**In respect of application for Discharge of Condition 10 – Construction Management Plan**

**APPLICATION NO: LU/295/19/DOC**

**Description of Works:** Approval of details reserved by condition imposed under ref APP/C3810/W/18/3197149 (LU/162/17/PL) relating to Condition Nos 9 - landscaping, 10 - Construction Management Plan, 13 - vehicular visibility splays, 14 - pedestrian visibility splays, 16 - cycle parking and 18 - street lighting.

Construction Management Plan Layout

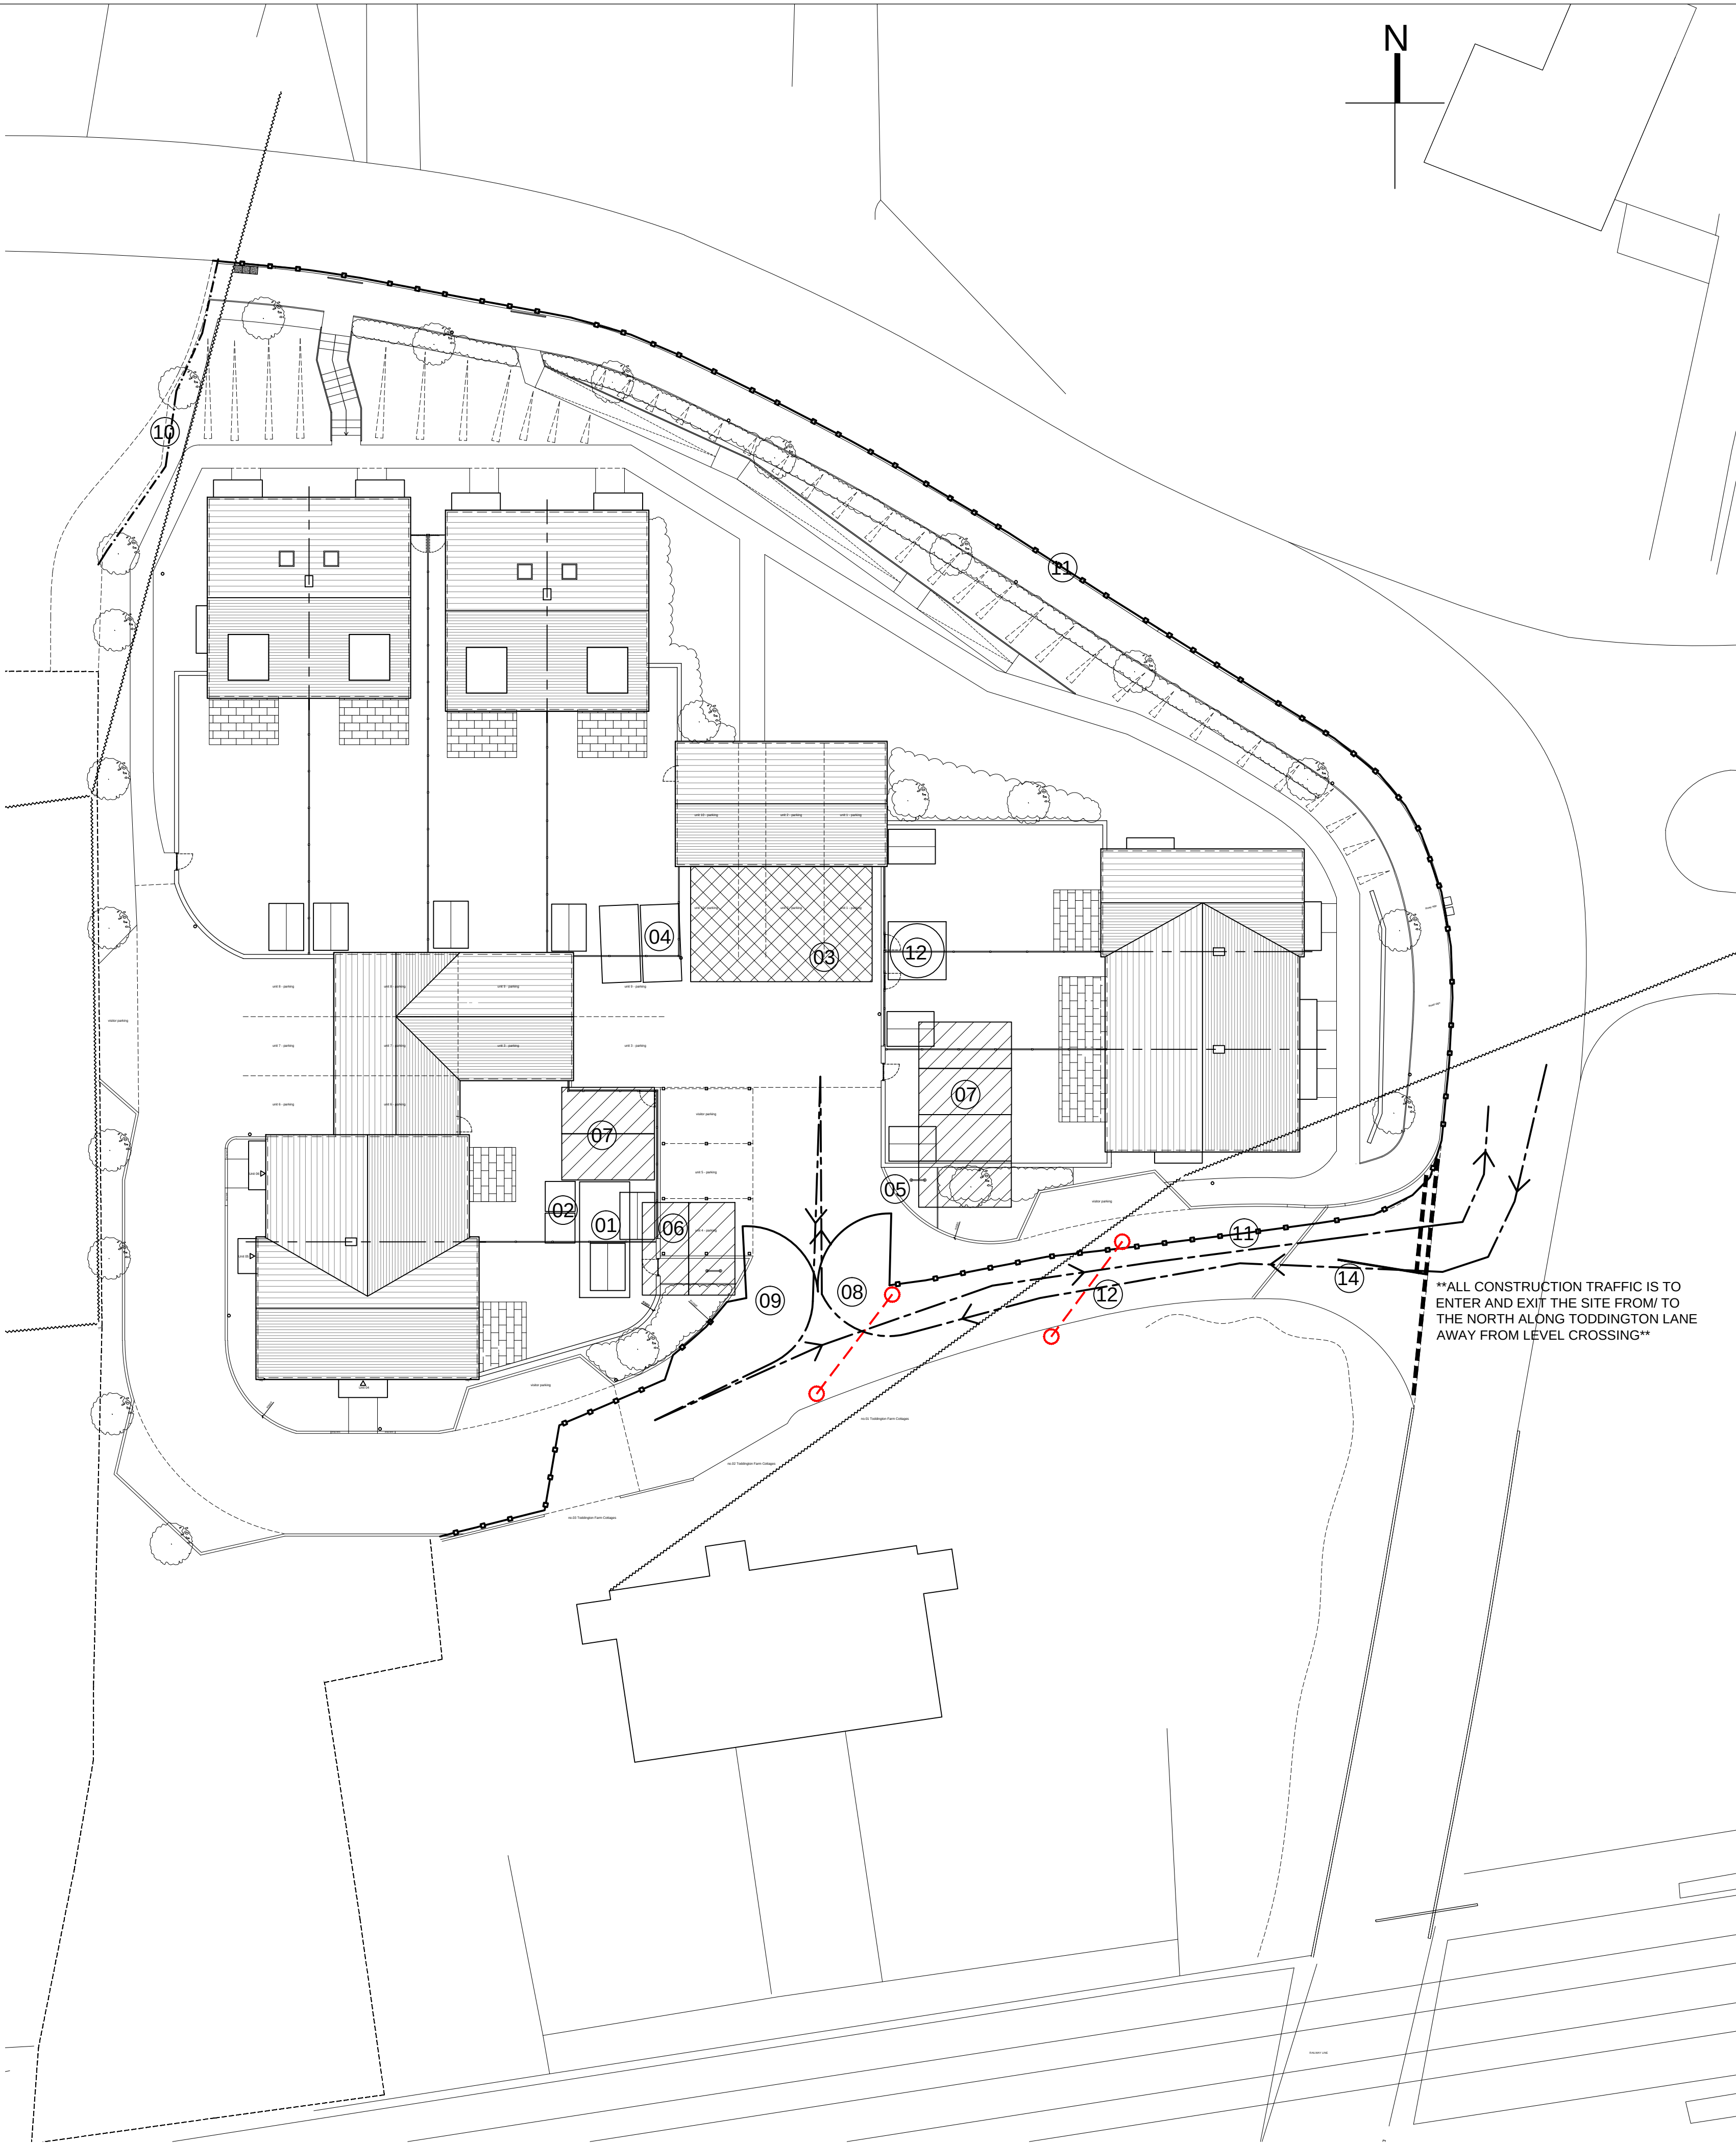
\*Page 8, end paragraph 2.2. 'Materials stored in dedicated areas.' Please can the applicant provide a plan showing the intended location of such storage facilities.

In regards to the second item, the material storage area has been indicated on the CMP Layout, and is referenced area no.03 – located within the 'inner courtyard' area adjacent to the car ports.

DRAWING TITLE
Construction Management Plan Layout

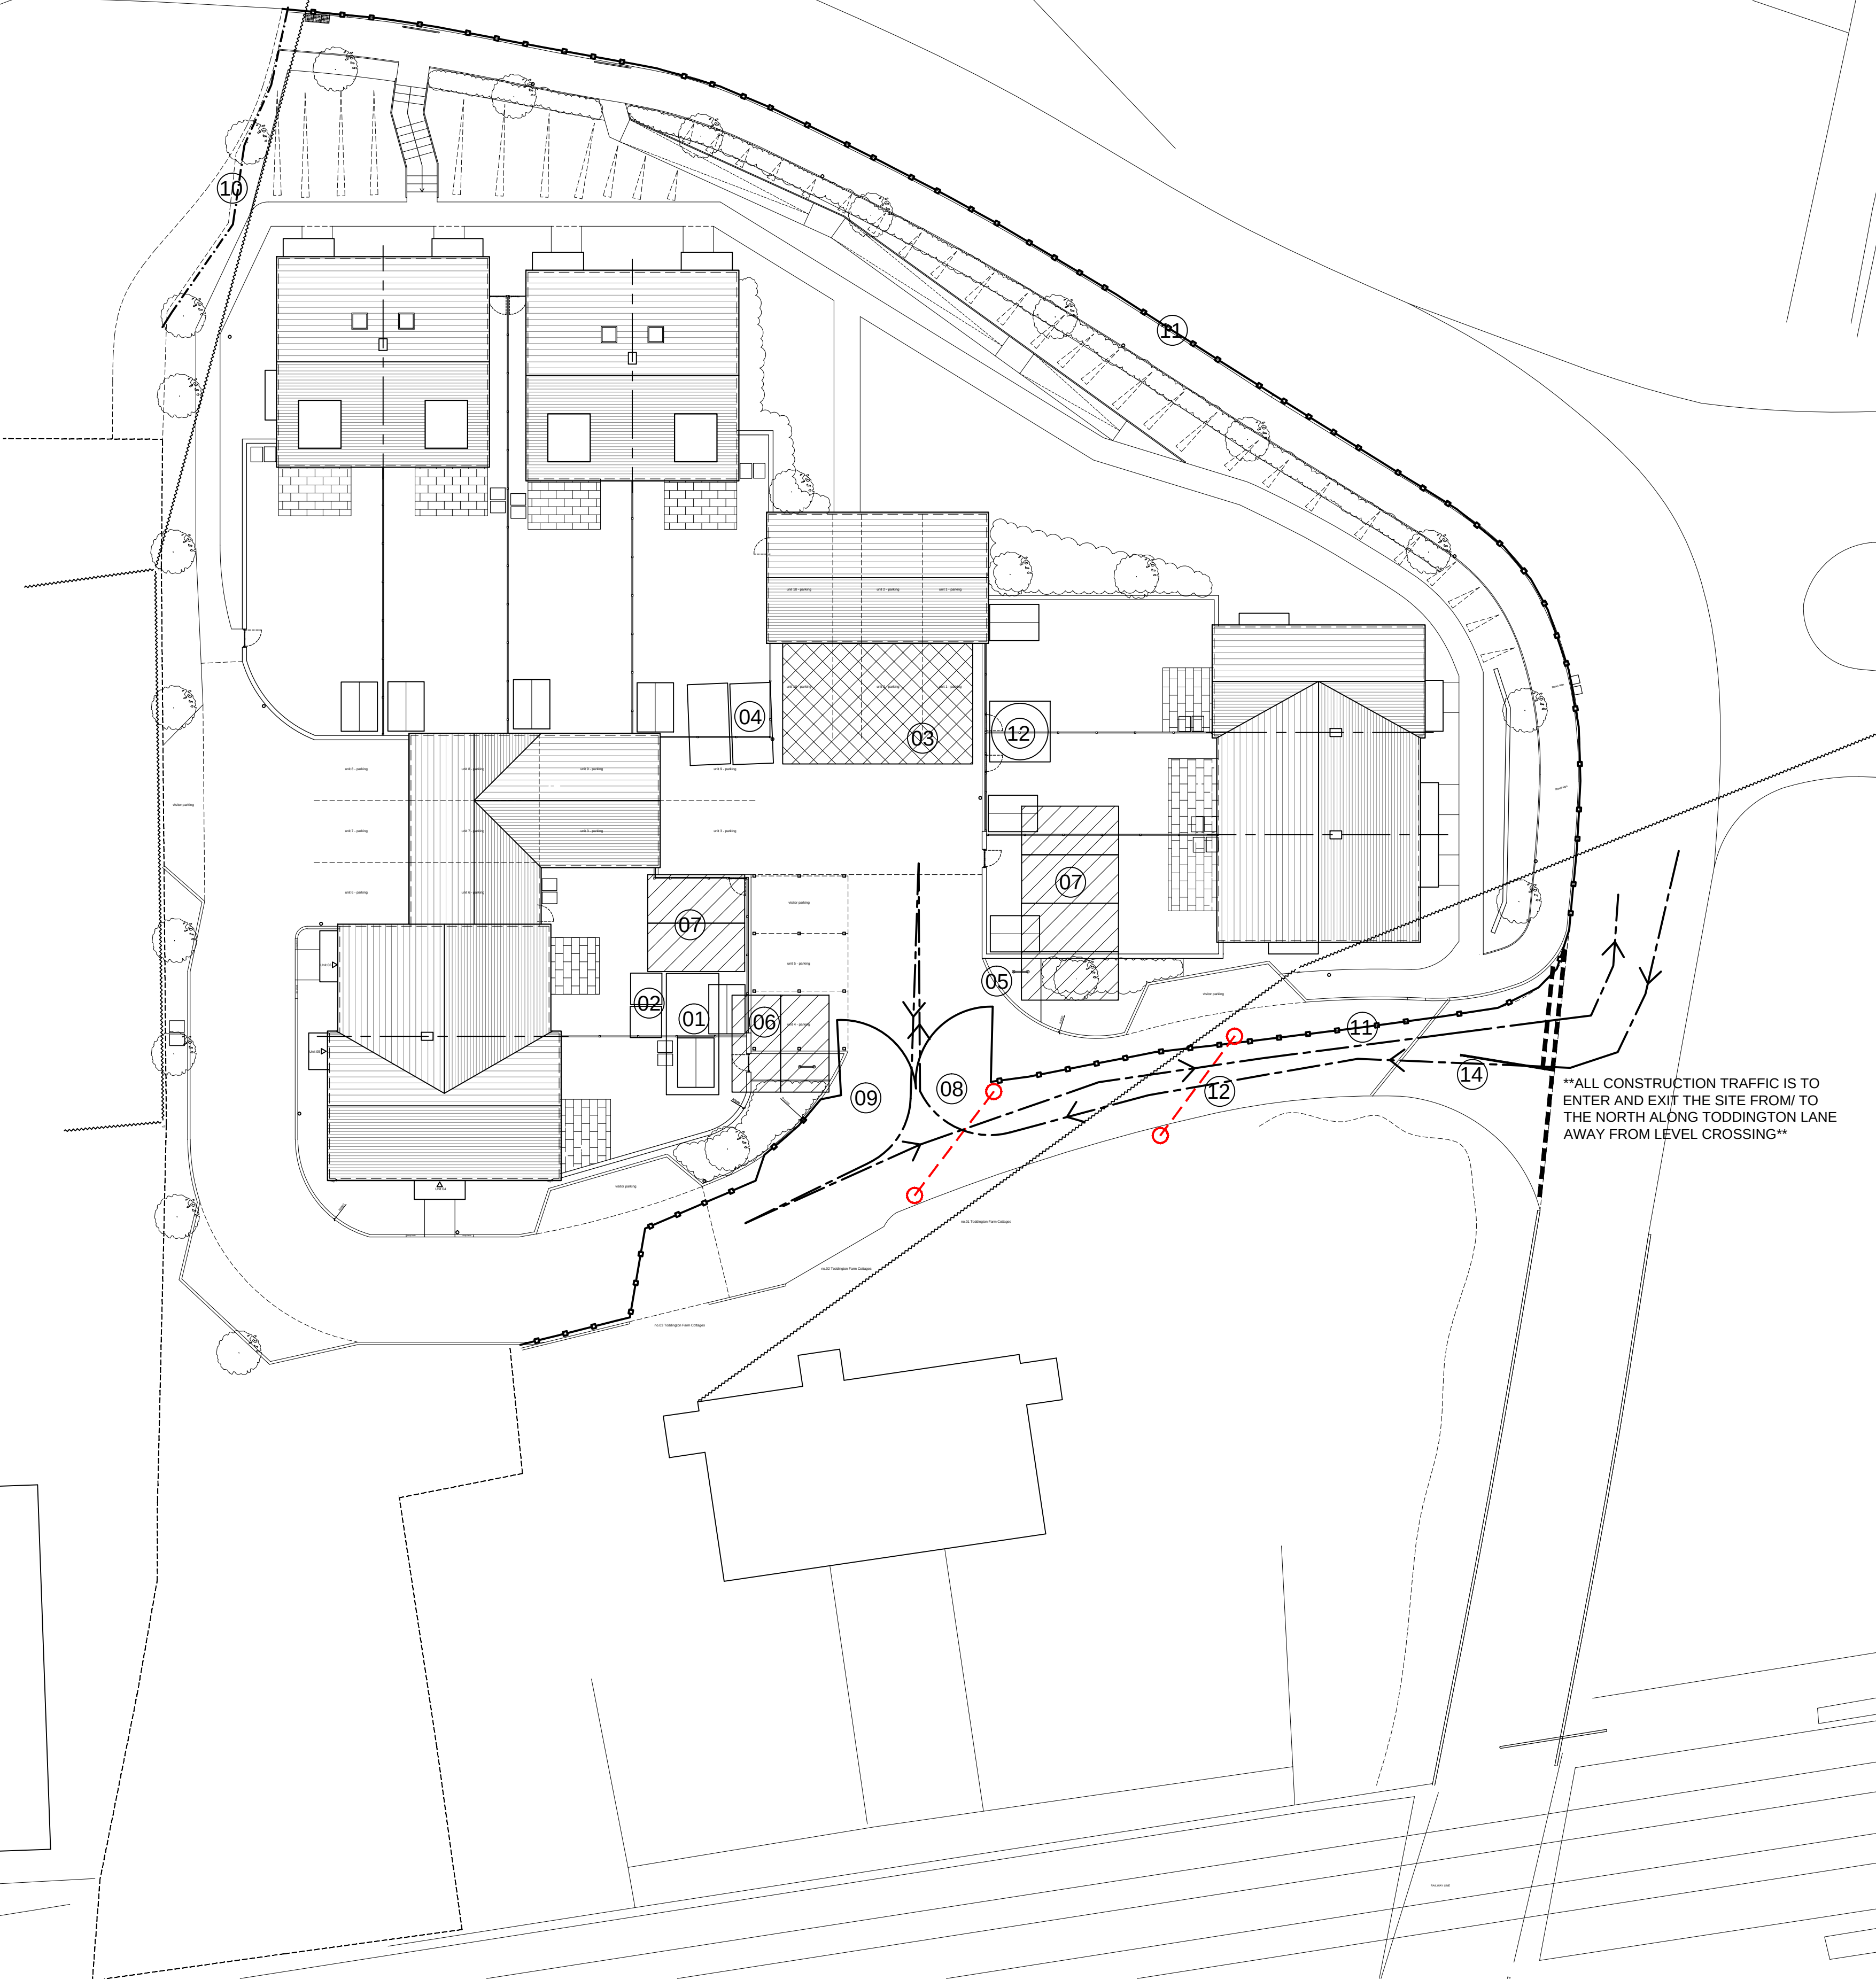
\*Page 8, final paragraph. Please can the applicant provide the intended nearby location for holding delivery vehicles prior to arrival on site.
